From: Scott Souders <scottsouders@mayberrycoloradosprings.com>
Sent: Tuesday, October 6, 2026 6:26 PM
To: Ryan Howser
Cc: John Mick; Randy Goodson; Alaina Marler; Katie Carleo; Mindy Schulz; Meggan Herington
Subject: RE: EFPD comments

Subject: EFPD comments

Ellicott Fire Protection District cannot support the spacing of homes three feet from the property line creating urban level development being protected with rural resources and a water supply that does not meet the El Paso County Land Development Code of 3,000 gallons per dwelling unit and 300 gallons an acre. The existing development and this phase will require in excess of 1,000,000 gallons of water. The adopted fire code is less stringent on this issue per the ordinance that adopted it and no alternate design standard has been presented for review.

Proj. Name:	Mayberry Phase 2
Location:	El Paso County
Plan Set:	PUD Development Plan & Preliminary Plan
Sheet Name:	Preliminary Landscape Plan

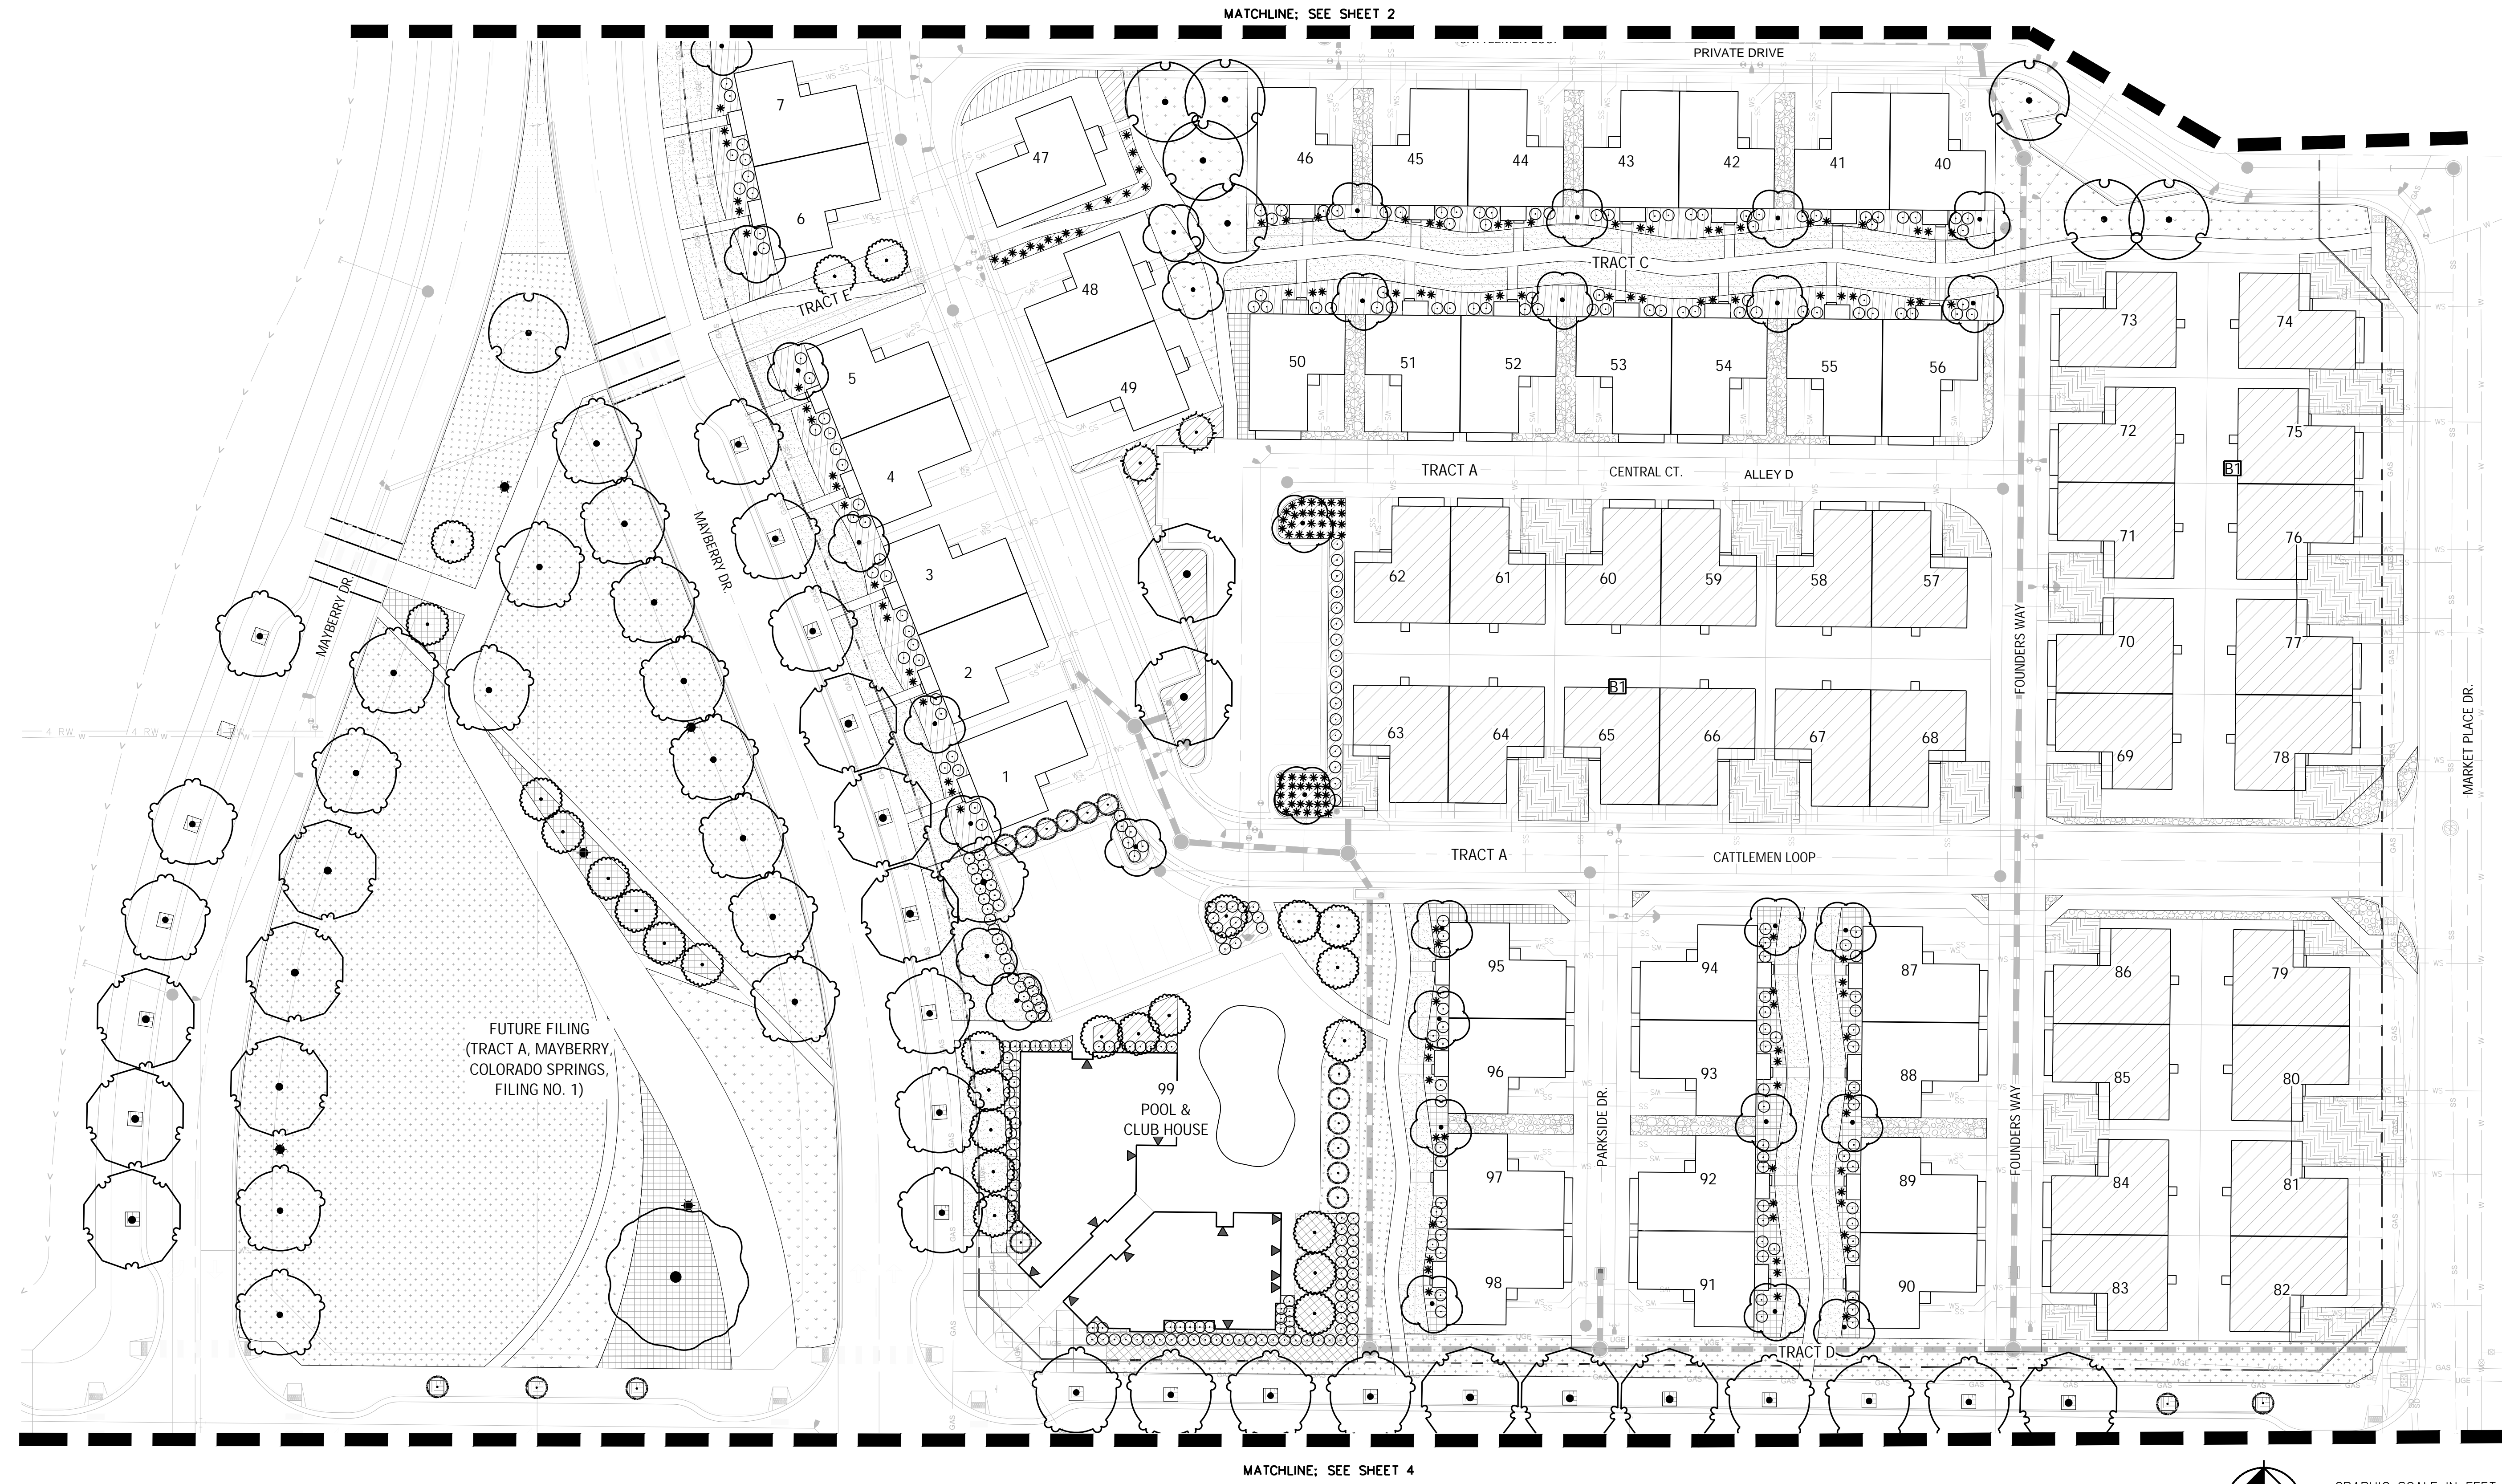
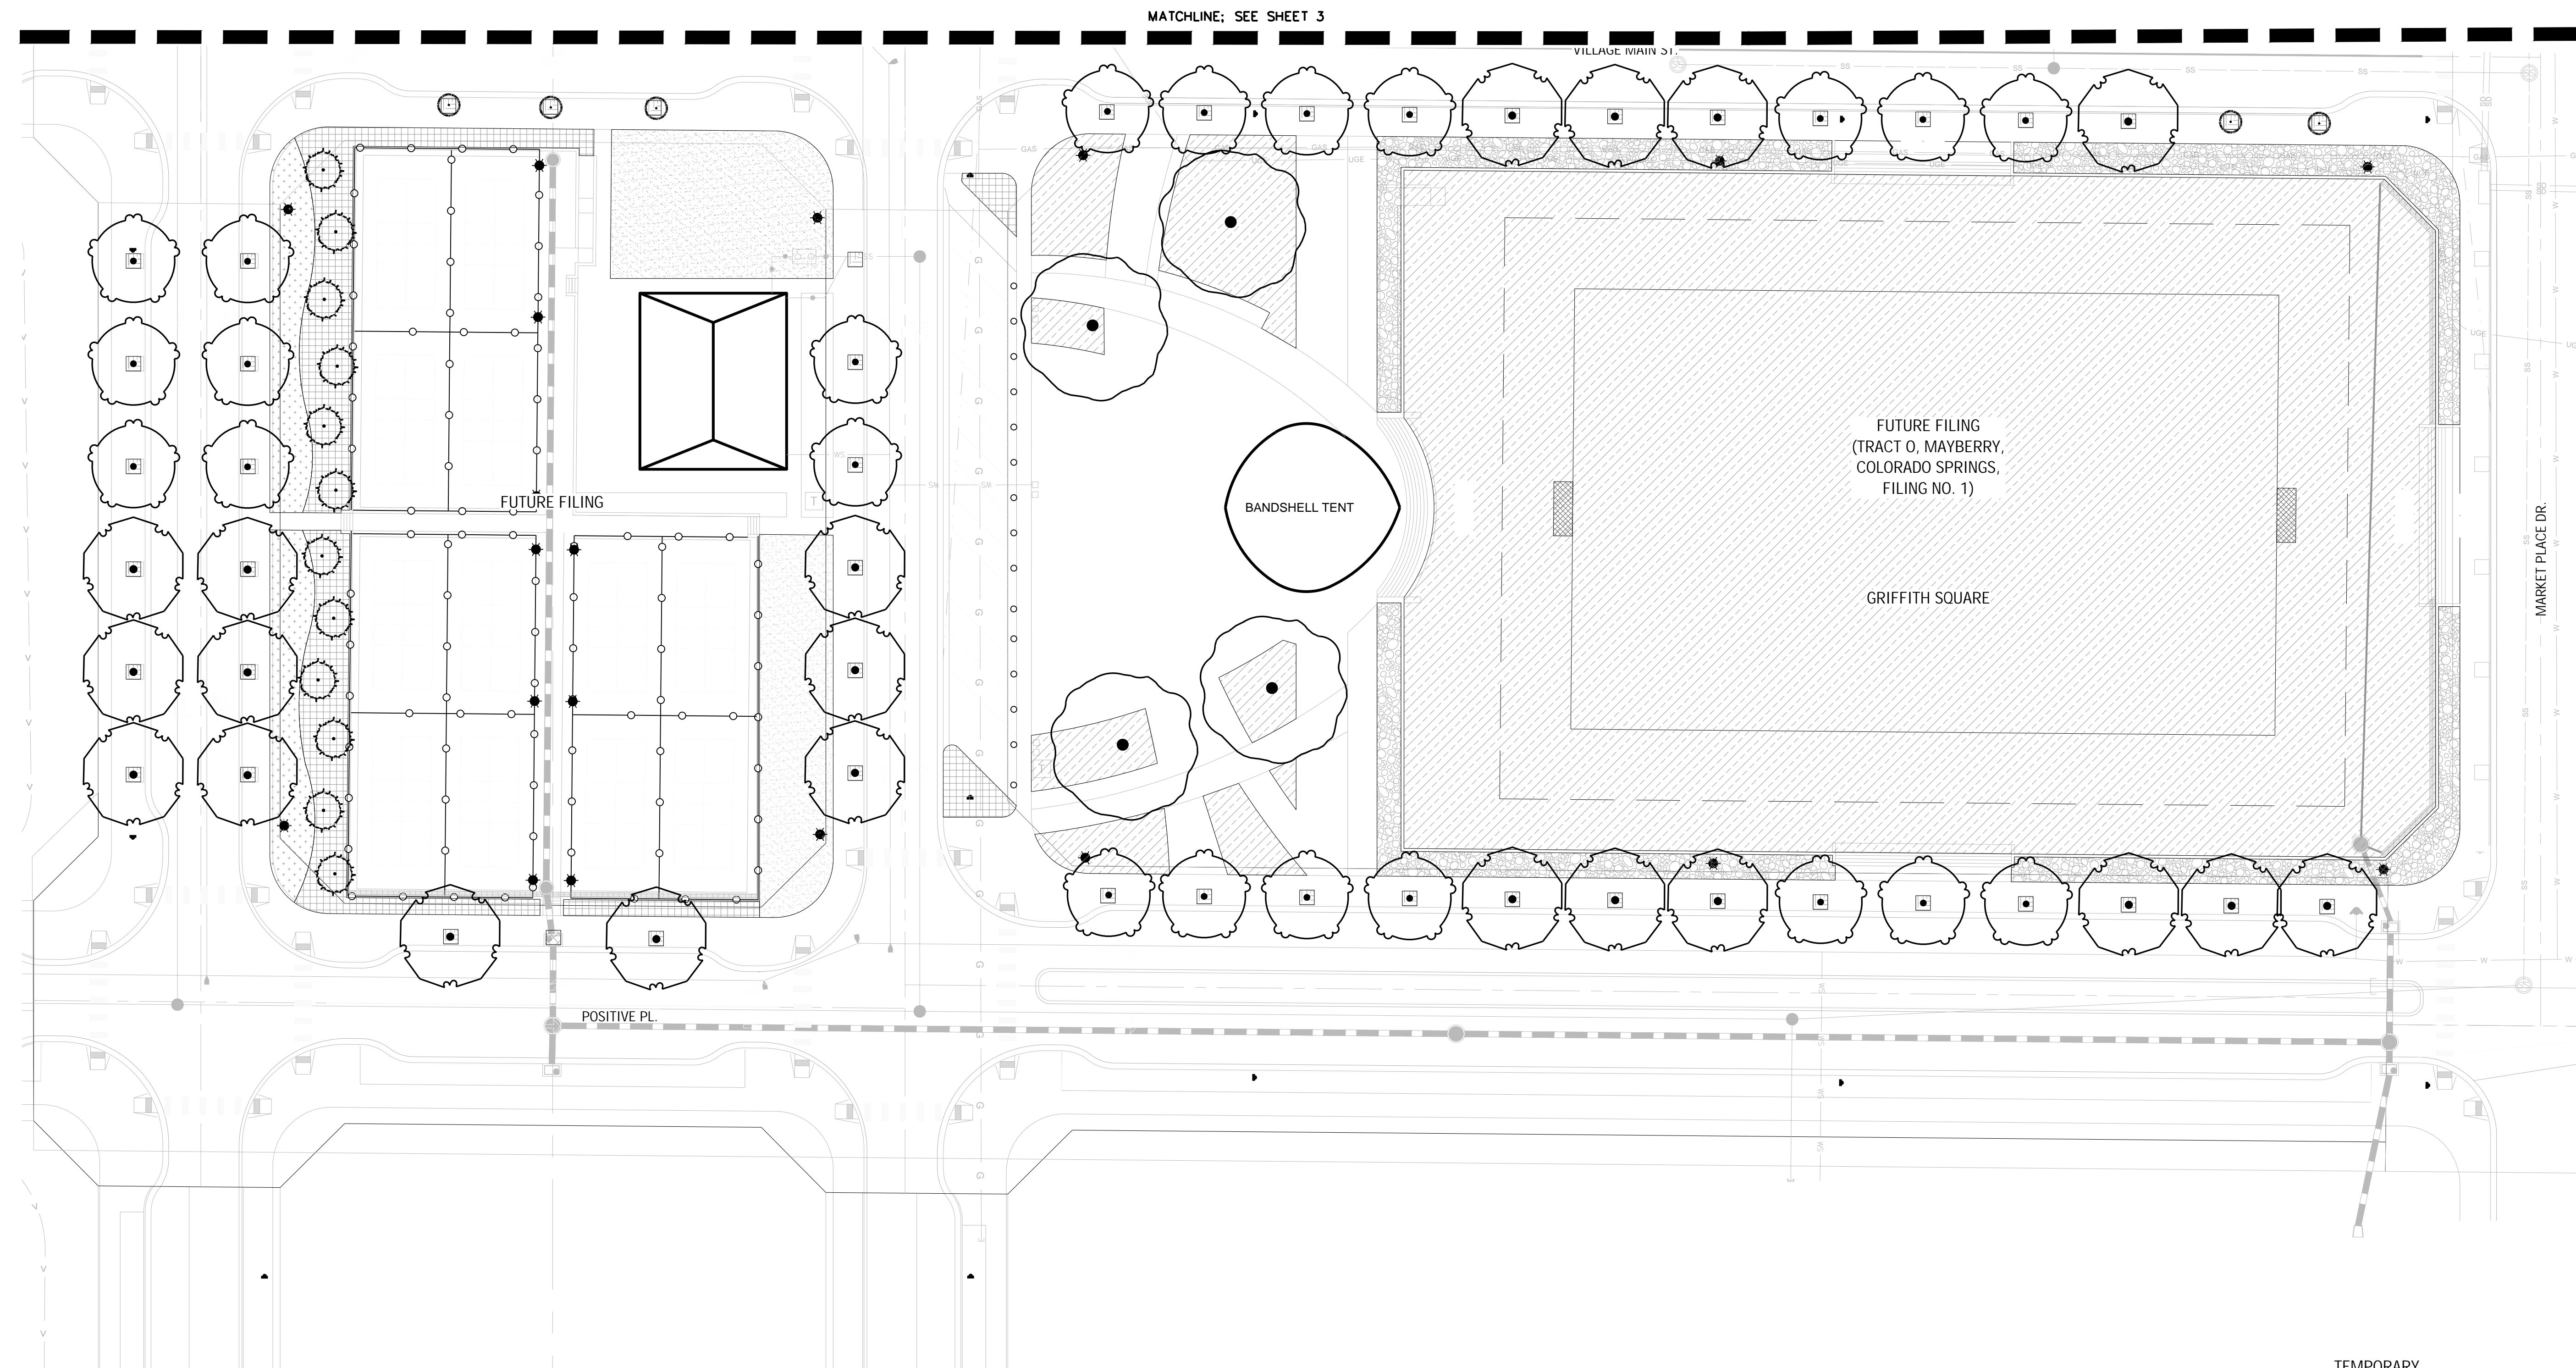
The PUD and the Landscape plans do not refer to the Colorado Wildfire Resiliency Code.

Finally, we have all discussed that the referenced CWRC is not applicable to this application as the referenced code was adopted after Mayberry’s Phase 2 PUD application was in process, and after Mayberry’s Sketch Plan was approved by BOCC and recorded. Although the CWRC is not applicable, Mayberry has been actively attempting to work with EFPD to establish ground truthing clarification. Each attempt has been met with a refusal to accept our findings of fact demonstrating that Mayberry is not within a wildfire hazard area.
